Rezoning Transportation Analysis
Petition Number: Insert Zoning Petition #2021-047
General Location Identifier: Tax ID 04924207

Revision Log:

Date	Description
04-29-2021	First Review (WB)
05-27-2021	Second Review (WB)
06-30-2021	Third Review (WB)

Transportation Summary

RZ-2

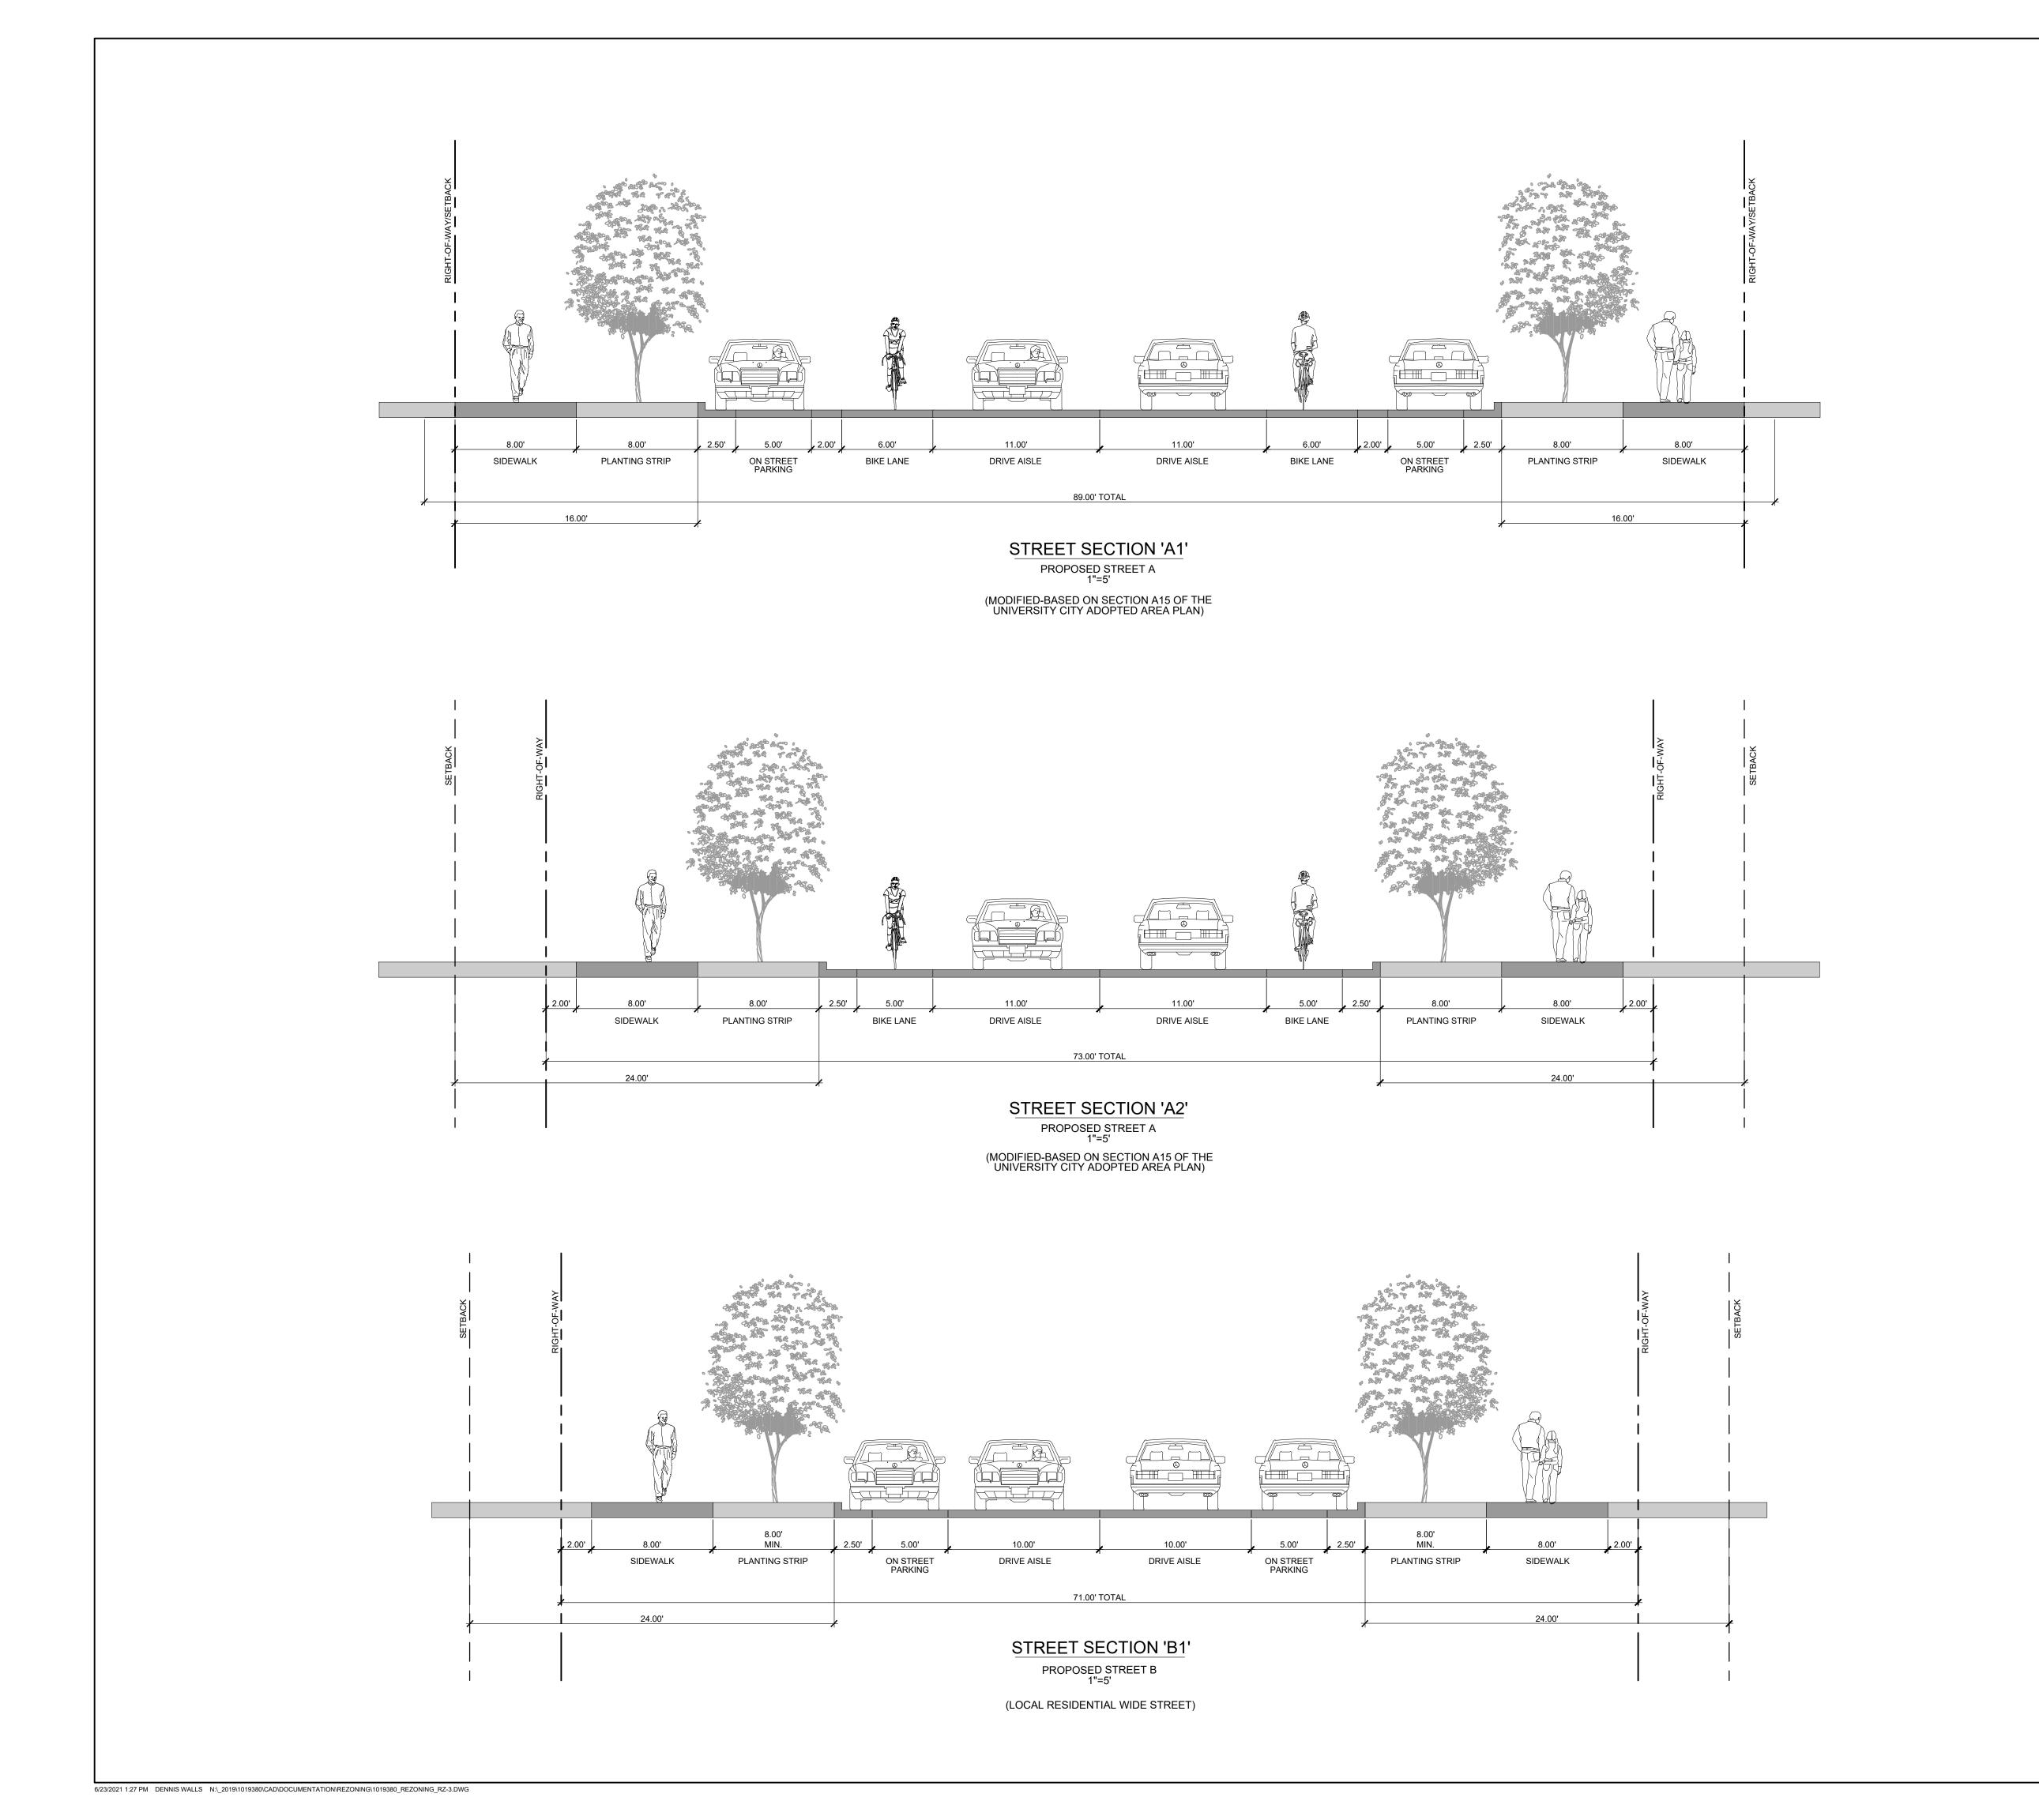
~~2. Please provide clarification on the two new site plan conditional notes listed under 3. Transportation Improvements and Access. | Proposed Improvements, c and d.~~
